CONSTRUCTION DOCUMENTS MAYBERRY, COLORADO - FILING NO. 2A

MAYBERRY PUD PH 1 - FILING NO. 2A

CONSTRUCTION DOCUMENTS			
JOB NO.	MC22199	ORG. SUBM. DATE	12/22/2022
DWN:	JMP	CHKD:	CJD
NAME

INITIAL EROSION CONTROL MEASURES

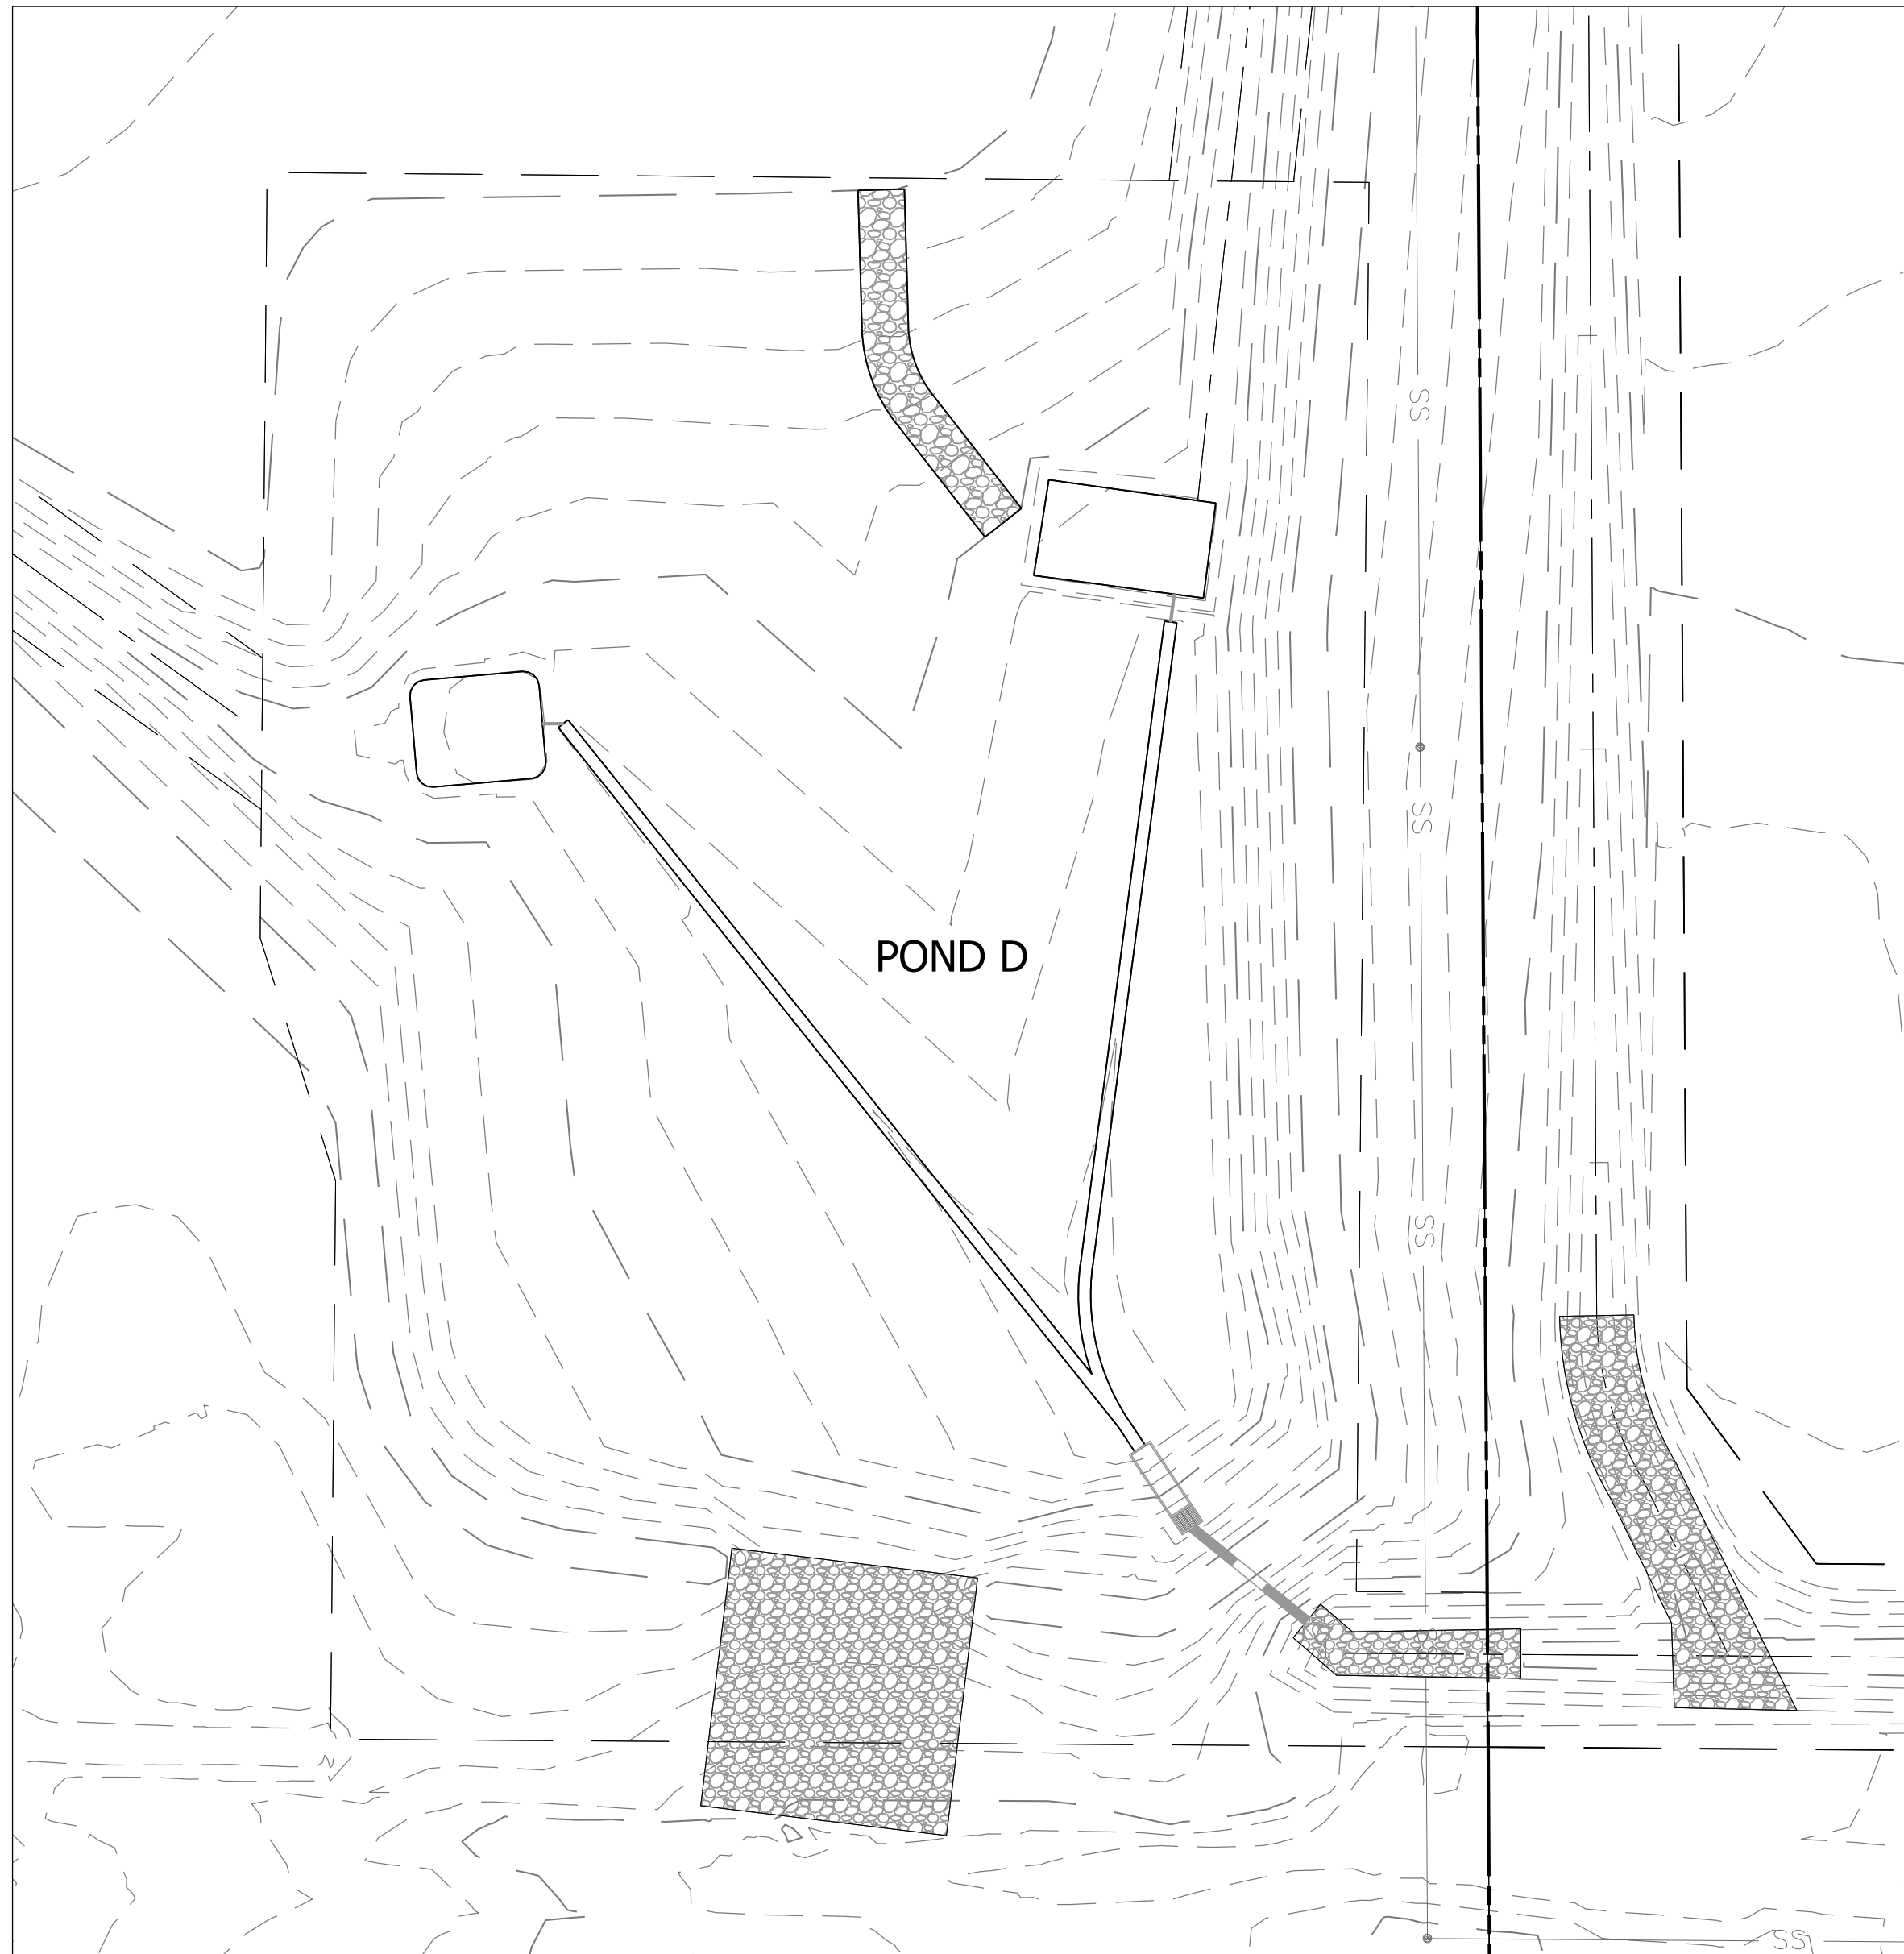
Added property parcel numbers.
GEC Checklist Item b - Provide property parcel numbers.
Note: all general comments regarding GEC Plans will apply to all phase sheets.

Added viewport to show off-site pond.
Show off-site pond the site is tributary to to satisfy GEC Checklist Item bb

SWMP Checklist Item 17e - provide SSA and areas used for storage of building materials, soils, or wastes. If TBD show in plan view and add a note stating final location will be up to the contractor.

GEC Checklist Items H and M. If "limits of disturbance" and "construction boundary" are the same, change to "limits of construction/disturbance" or otherwise show as separate line types for each on the legend and figure.

GEC Checklist Item ee - Plan certified by CO Registered PE. Provide stamp prior to project approval.
PE stamp is now provided on sheets 9, 10, & 11.

Added SSA and CWA.
Note added for contractor to determine final location.

Revised to disturbance/construction.

INTERIM EROSION
CONTROL
MEASURES

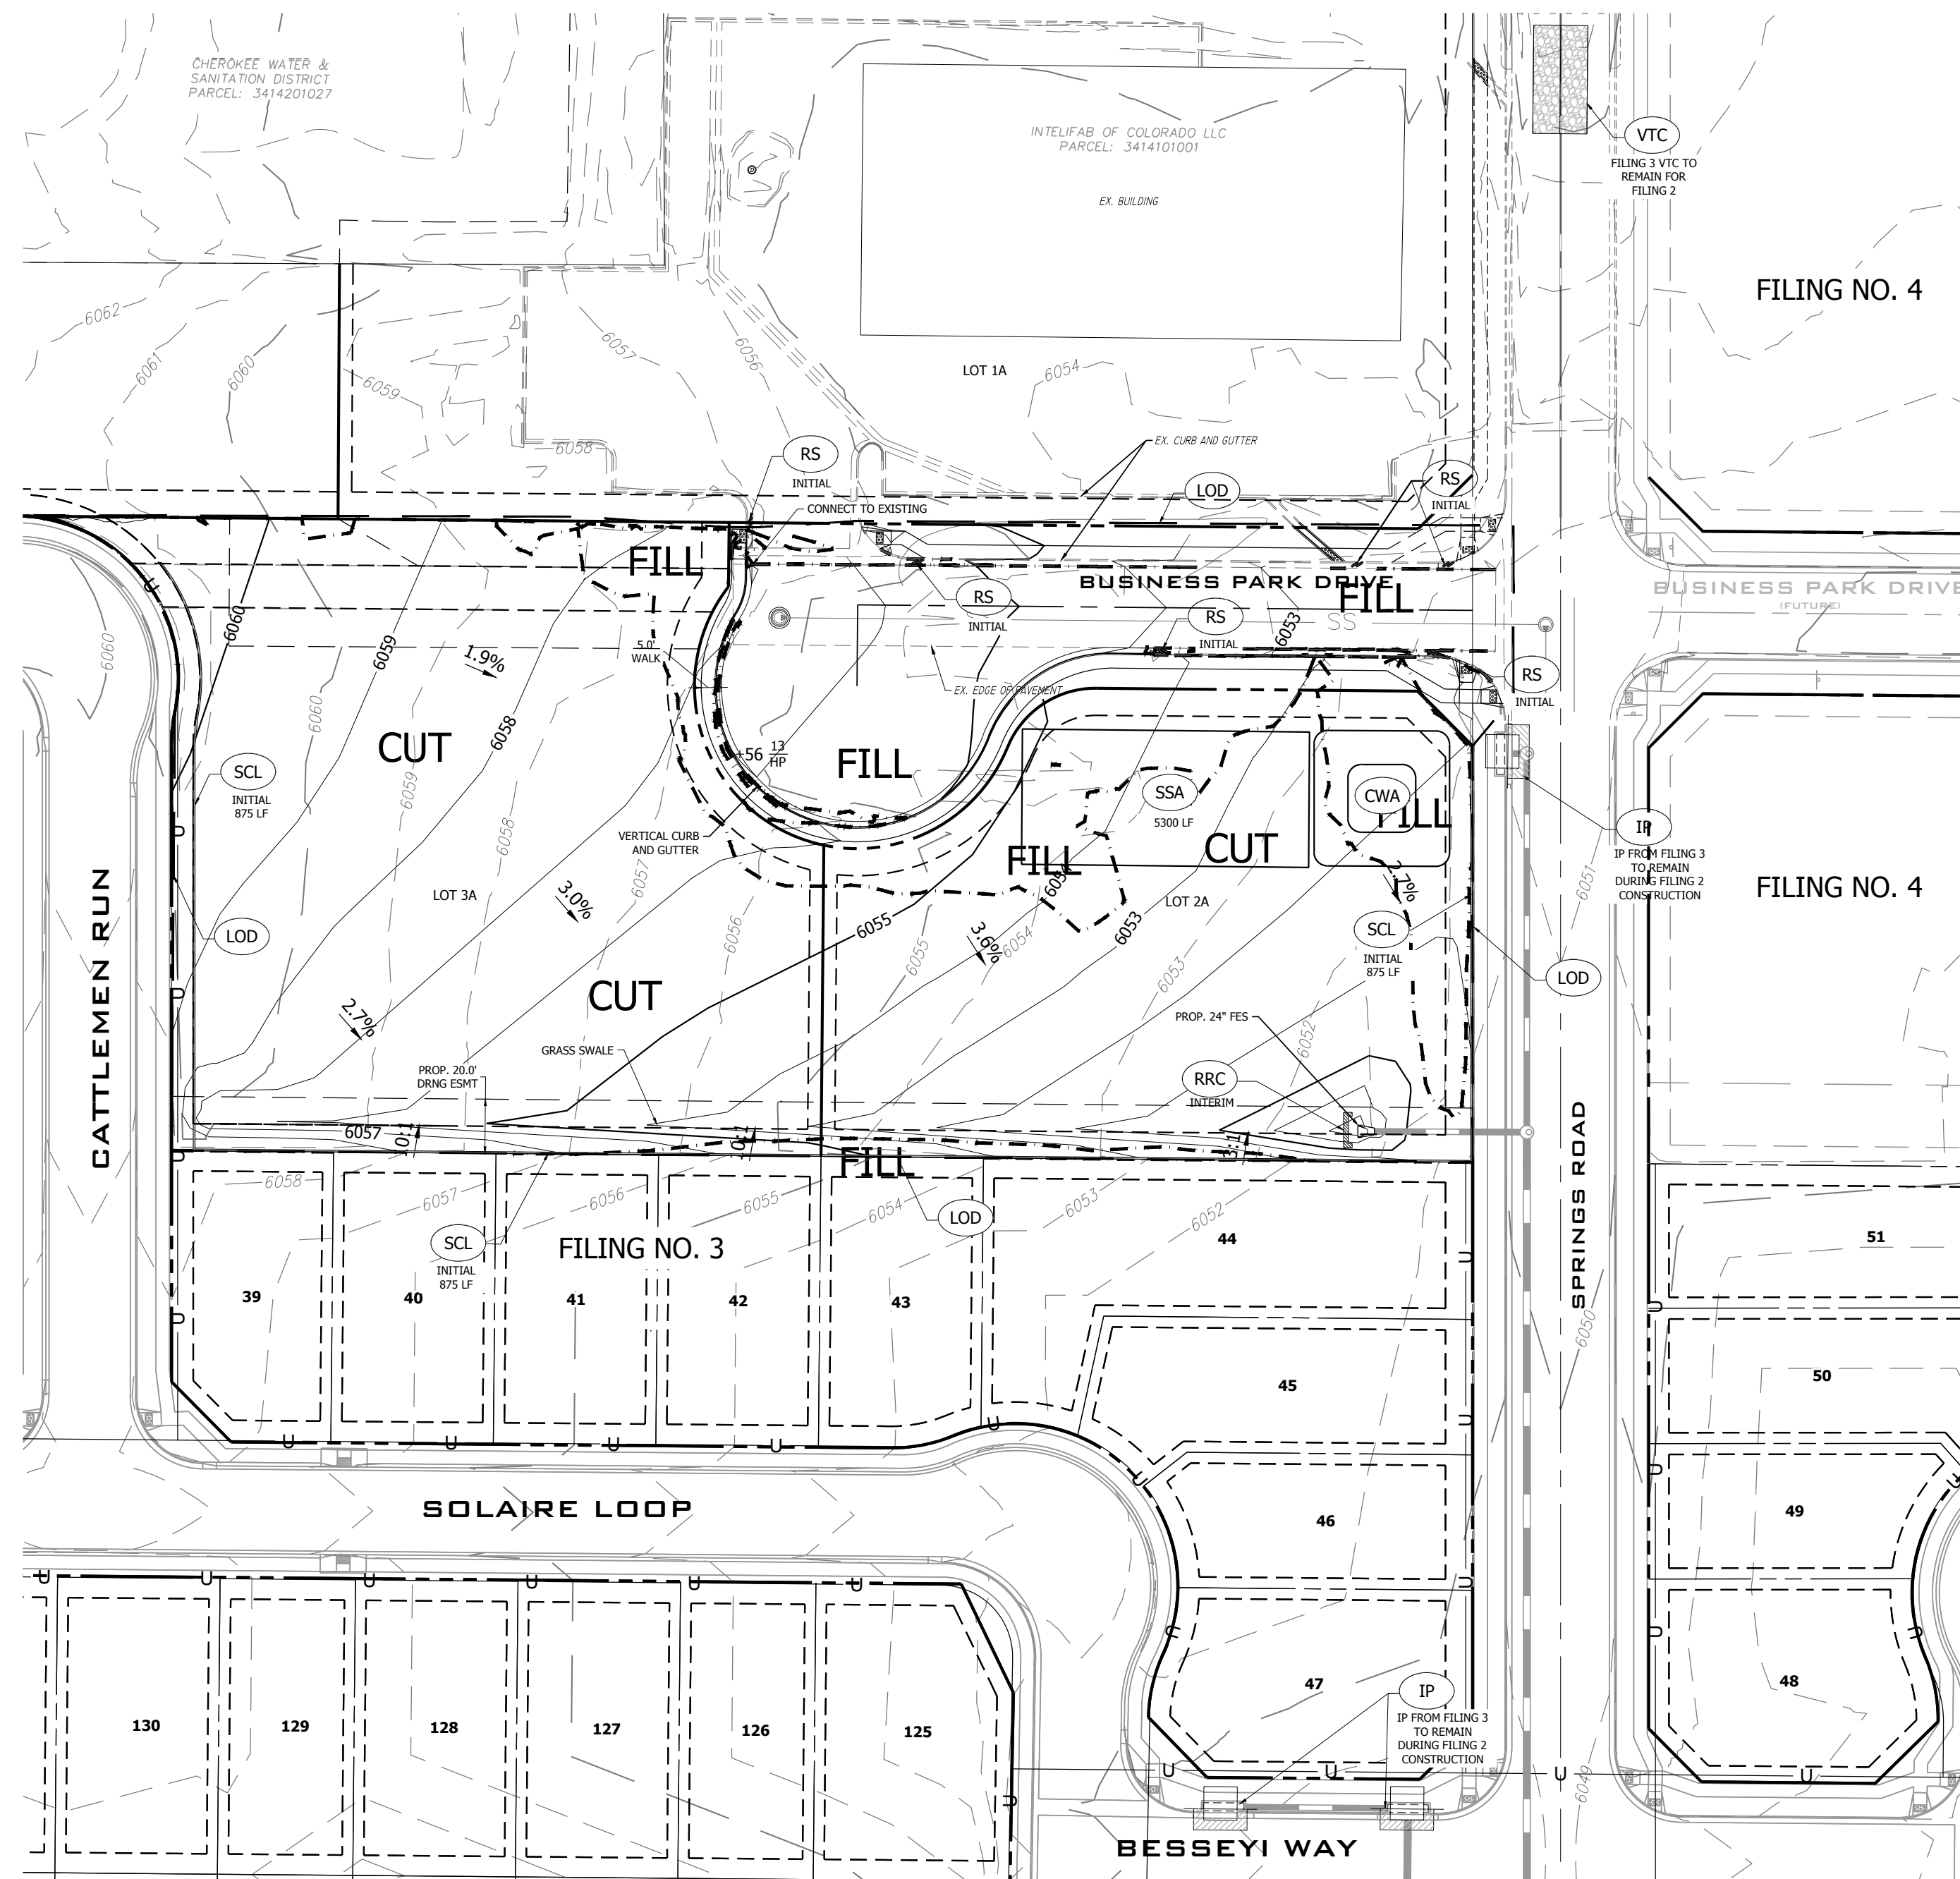
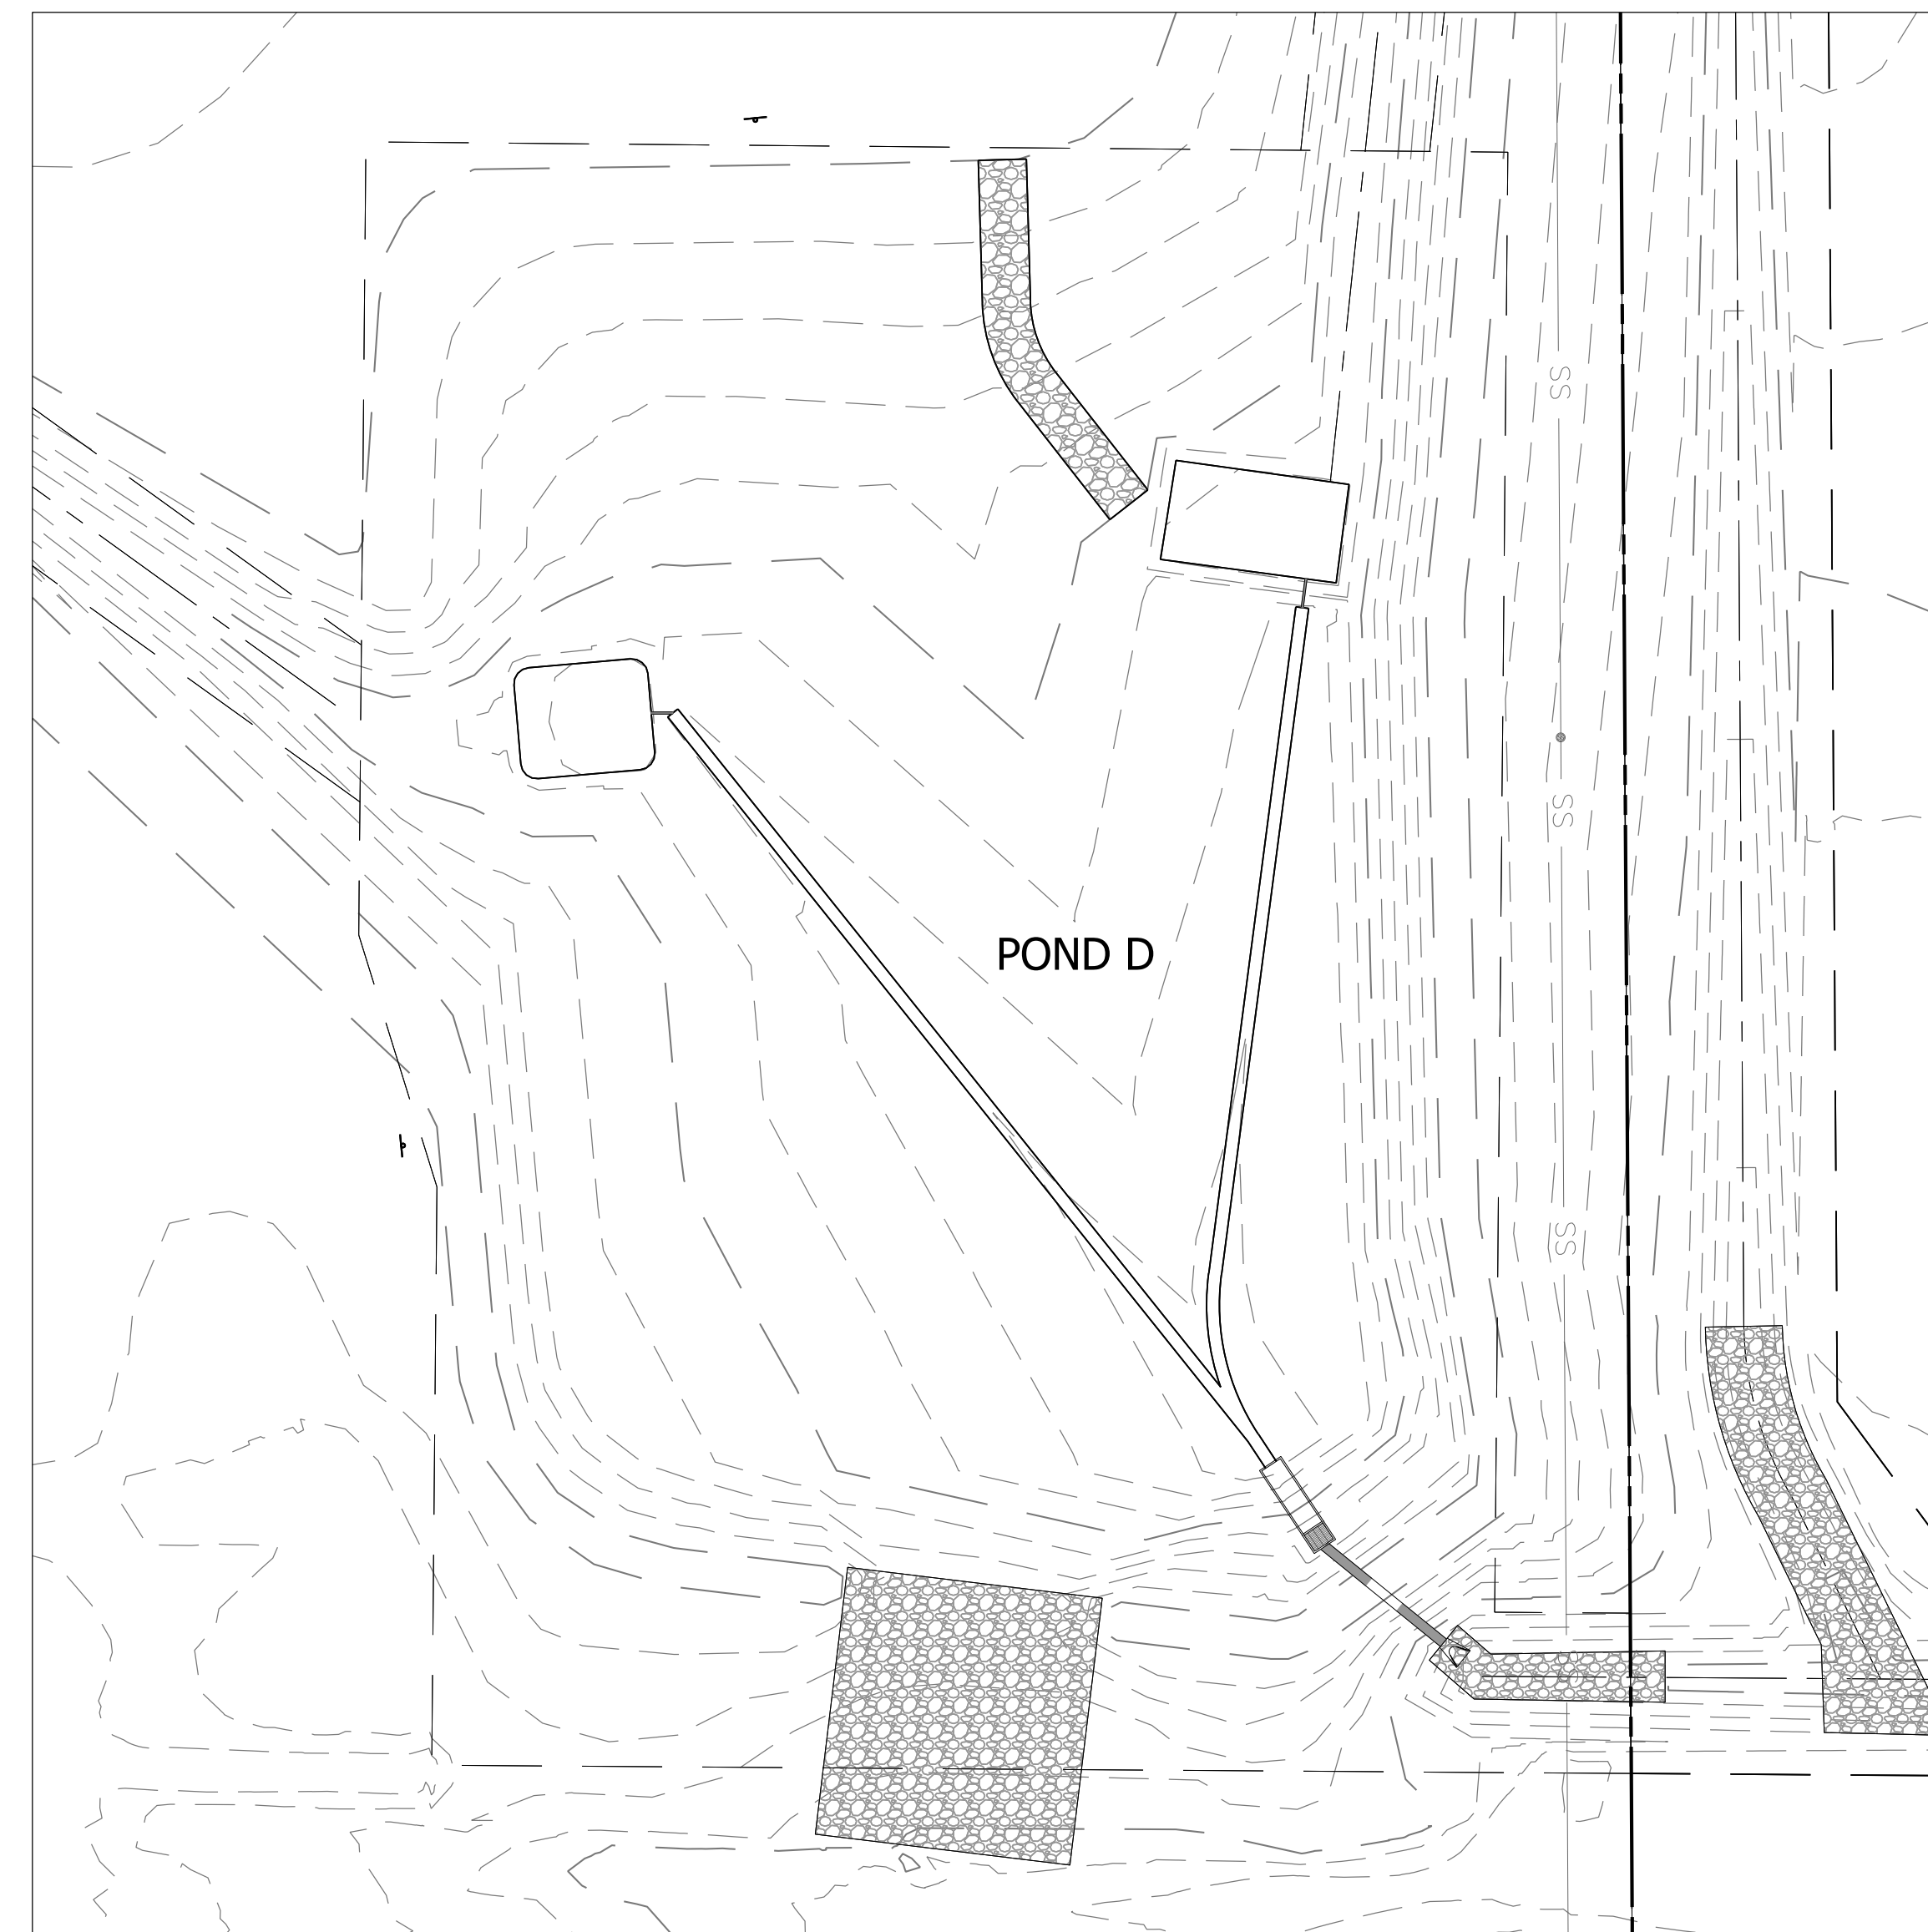
GEC Checklist Item b - Provide property parcel numbers.

Show off-site pond the site is tributary to
to satisfy GEC Checklist Item bb

GEC Checklist Items H and M. If "limits of disturbance" and
"construction boundary" are the same, change to "limits of
construction/disturbance" or otherwise show as separate line
types for each on the legend and figure.

Added property parcel
numbers.

Added viewpoint to
show off-site pond.

Revised to
disturbance/construction.
